From: Town Planning <town.planning@hs2.org.uk>
Sent: 05 January 2024 15:08
To: Michael Briginshaw
Cc: Sukhpreet Khull
Subject: RE: Planning Consultation for 2382/APP/2023/2906

OUR REF: HS2-LBH-SC-027

BROADWATER LAKE, MOORHALL ROAD HAREFIELD

Proposal: Redevelopment of the site to create the Hillingdon Watersports Facility and Activity Centre including demolition of existing Broadwater Lake Sailing Club (BSC) clubhouse at the north of the lake and erection of a building to be occupied by HOAC and BSC including changing facilities, meeting rooms, storage, Workshop and seasonal worker accommodation (sui generis), activity shelters; installation of pontoons and concrete slipways; boat shed; equipment storage huts (north of lake and at entrance); boat parking and racking areas; camping area; outdoor activity areas; ecological enhancement throughout the site; new pedestrian routes through the peninsula; landscaping including new woodland, dense vegetation screens and boundary treatment; new access and access road; localised dredging and land reclamation; relocation of existing sailing area and creation of floating and fixed islands within the lake; coach drop off and turning area; vehi

Figure 1: Location of permitted land-based activities

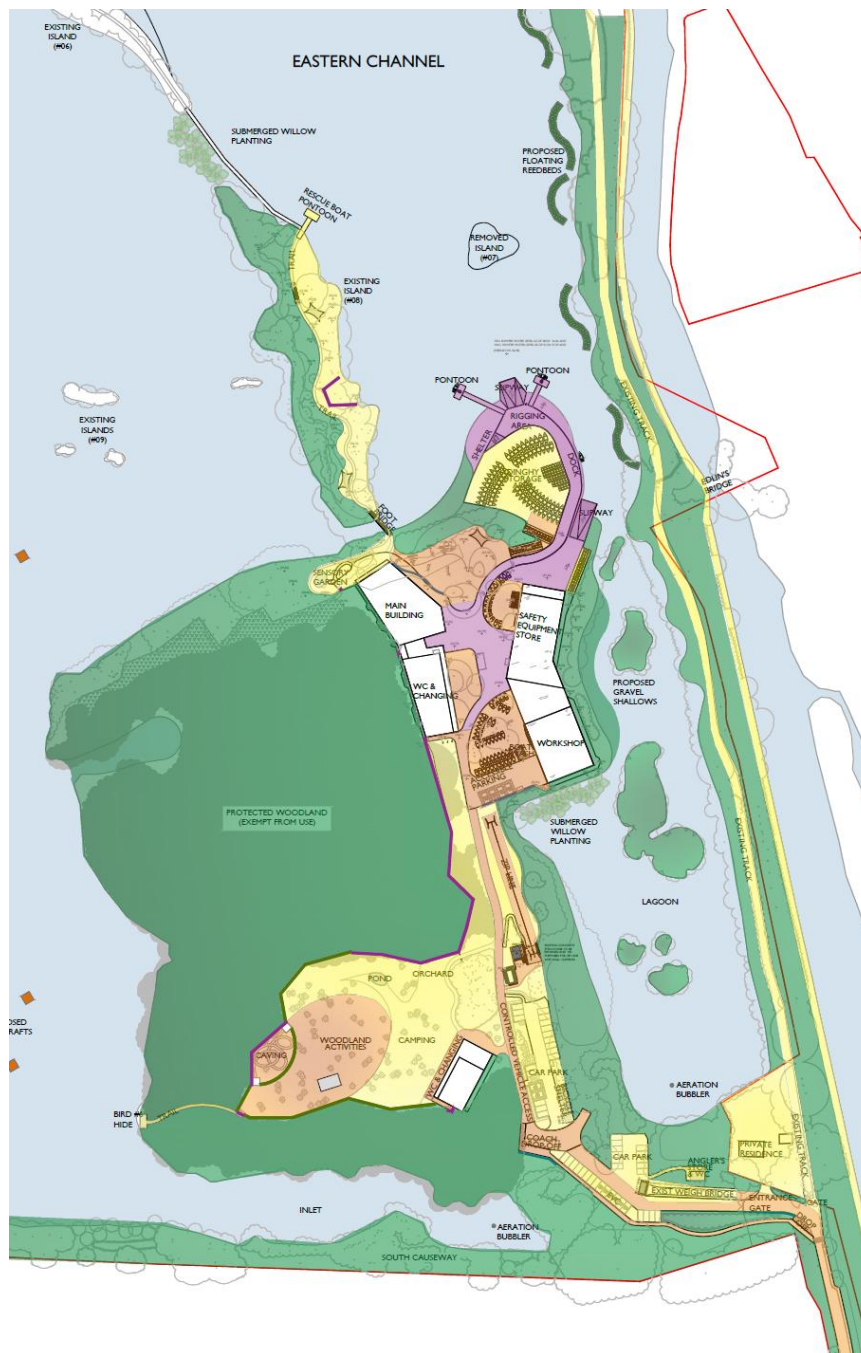
1. Will visitors/users of the camping and activity field be permitted access to the lake on the south-eastern shore, which is adjacent to location 32?
2. Will dogs be allowed on the premises? If so, will they be allowed to roam freely without a lead?
3. Can they confirm that sailing activities will not be permitted in the vicinity of the gravel floating islands, specifically at locations 32 or 45 as indicated in the ecological mitigation plan?
4. Do they intend to preserve the existing trees surrounding the land to the east of location 32 to act as a screening? Alternatively, are there plans to remove any trees in that area?
5. If the trees are to be left in situ, would it be feasible to install a fence surrounding the wooded area to restrict access by people and dogs?

Ecological Mitigation - Lake

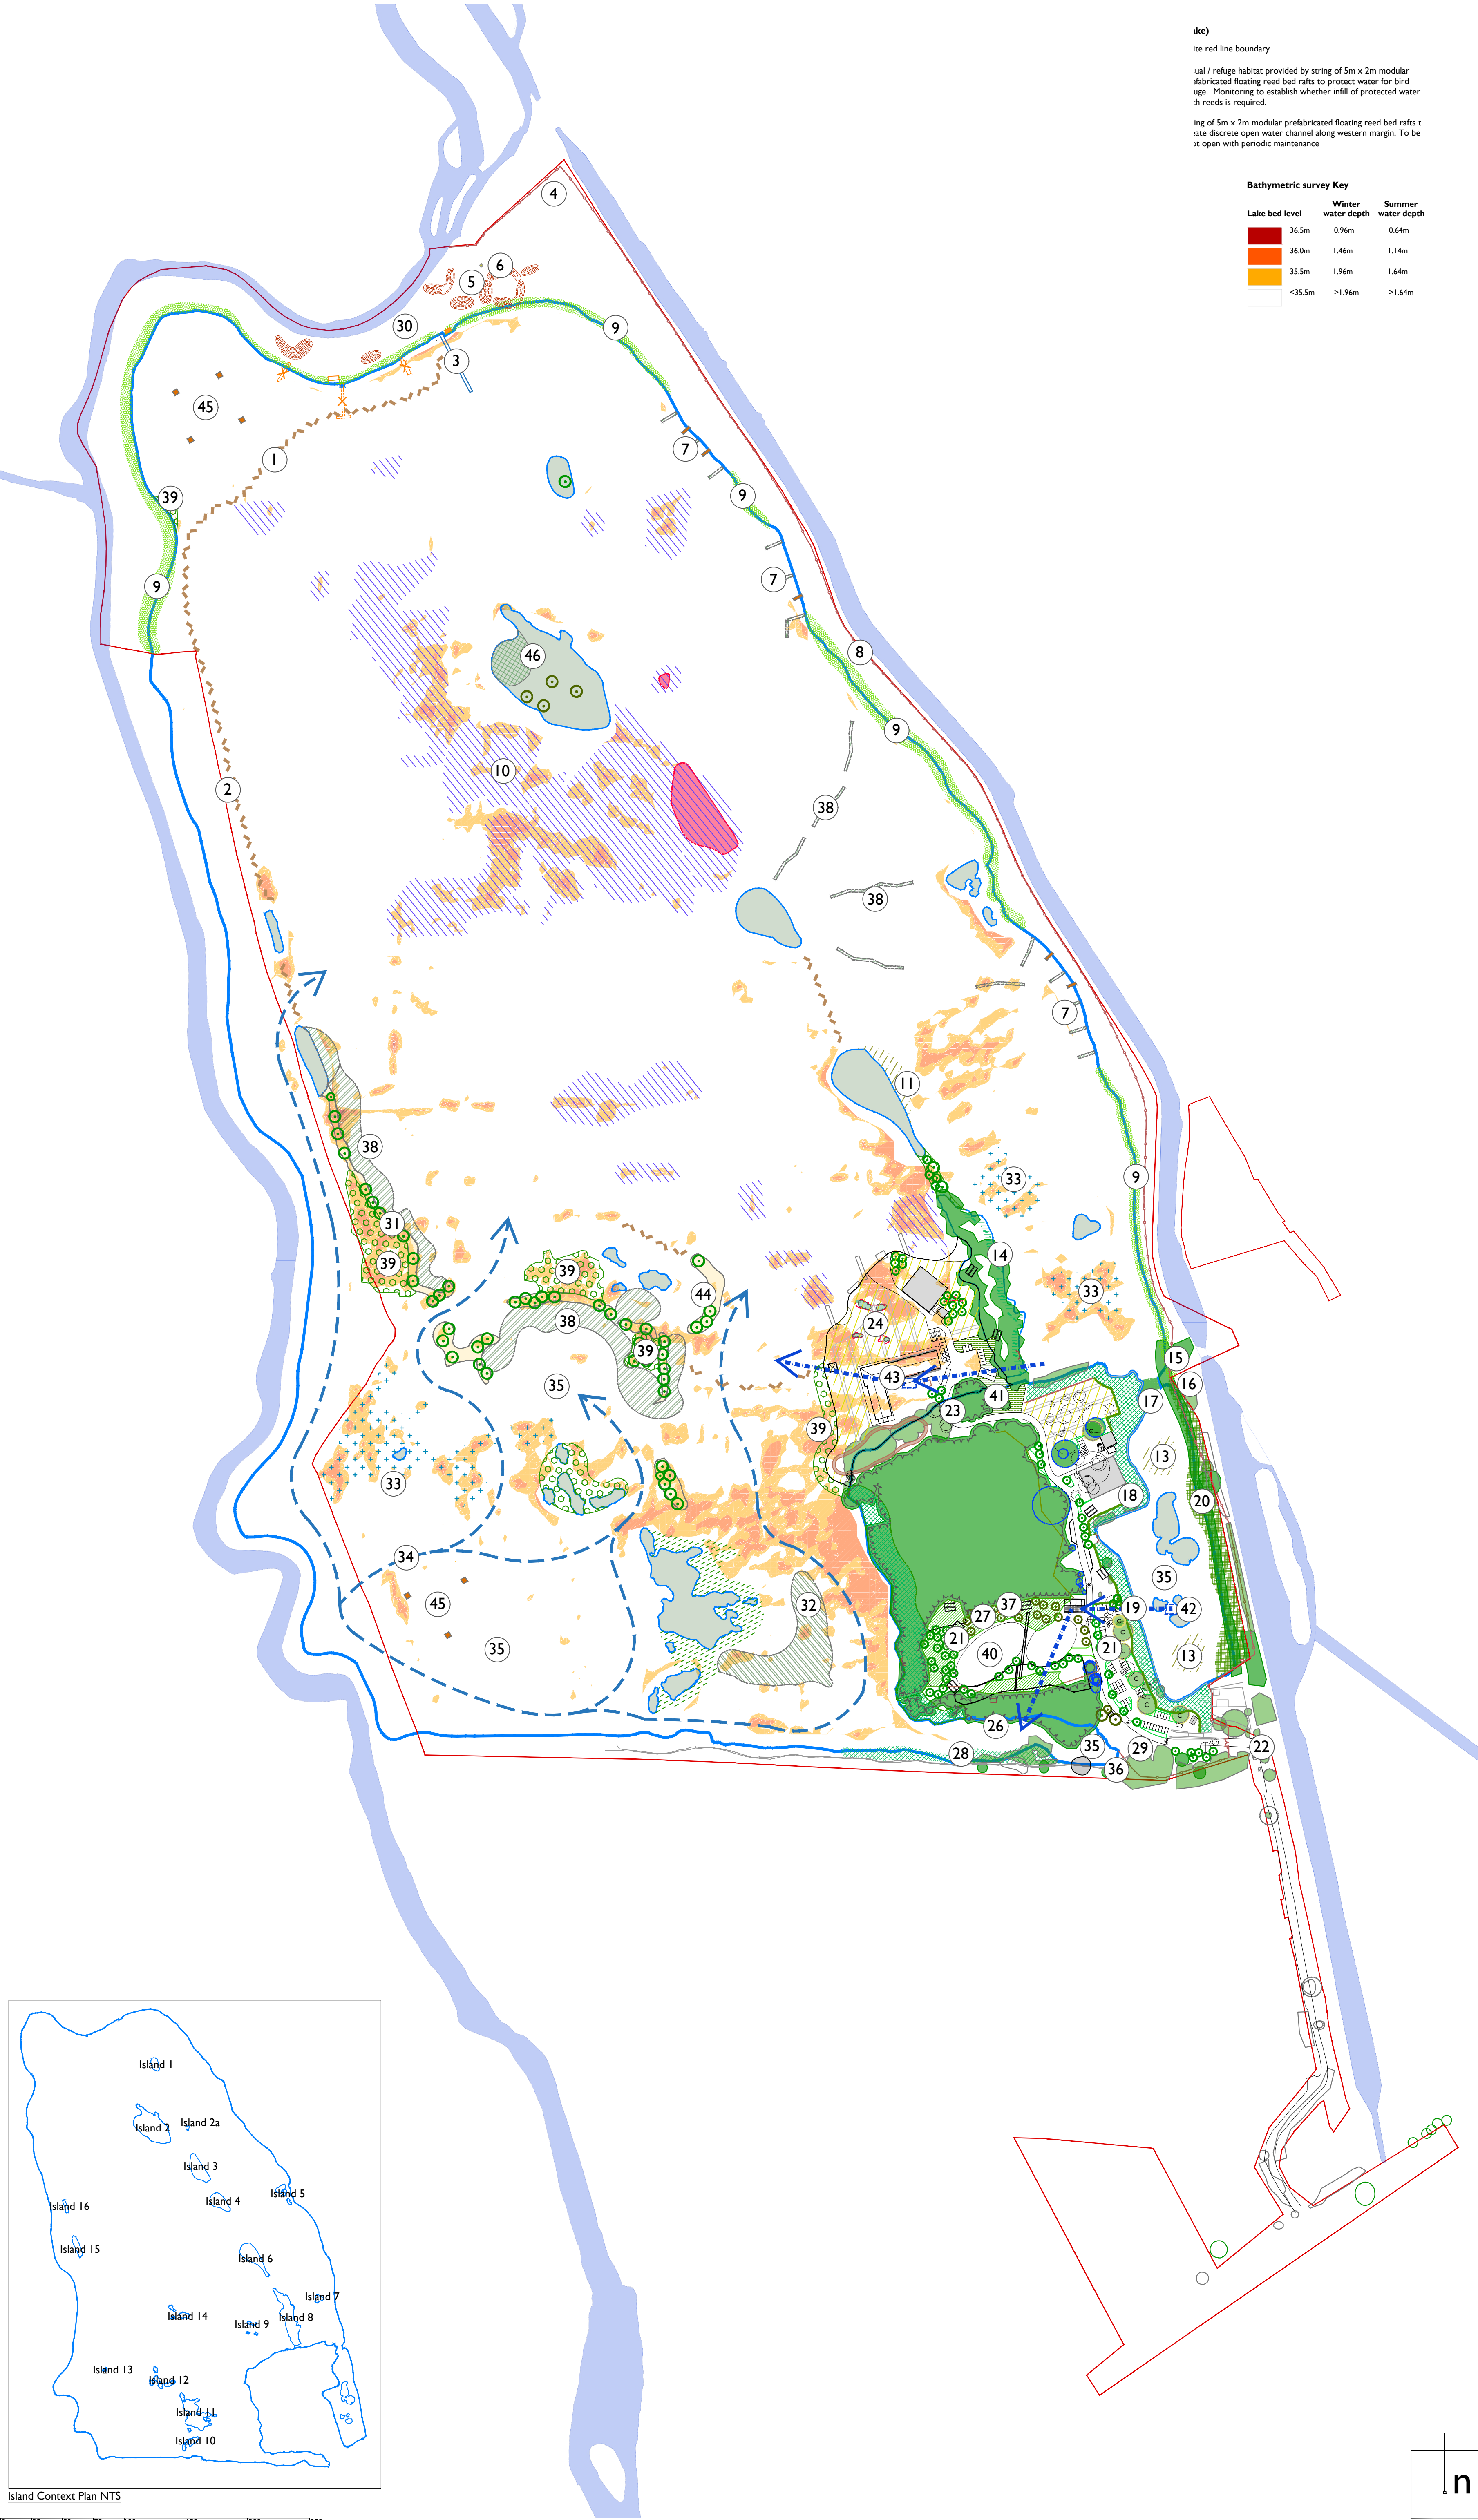
As previously explained in our email of 19 December 2023, HS2 Ltd have been assessing the application submission against our Environmental Statement ecological mitigation measures proposal at the same site known as the Broadwater Lake bird islands, i.e. several new gravel islands/rafts to be created in the south-eastern corner to provide nesting opportunities for water birds including gulls and terns. Whilst the application as submitted acknowledges these measures it suggests an alternative location to that which has powers under the HS2 Act 2017.

Having worked with our sub-contractors to formulate a comprehensive response to the applicant's proposal, HS2 have been advised that further information is required to ensure deliverability of the gravel islands is not hindered by the HOAC relocation proposal and to assess the effects and necessary mitigation that may be necessary should both proposals co-exist in this area compatibly, we have some questions to reach clarity.

Accordingly, please find below the additional information required by our technical specialists and the additional scope to assess relocating the gravel Islands to the south-western corner of Broadwater Lake. This assessment must consider the potential impact of a relocation of the gravel islands on HS2's Environmental Minimum Requirements (EMRs) providing assurance that the objectives of safeguarding the high-speed rail project are protected.

We would welcome a meeting with the applicant and yourselves to understand the proposed development better as there appears to be some uncertainty in plans of where the gravel islands are shown to be re-located. Also, with regard to respective construction programmes the following statement is noted from Chapter 6 – Construction of the application submission: *"6.8.19 There is no anticipated overlap with the enabling works phase of construction*
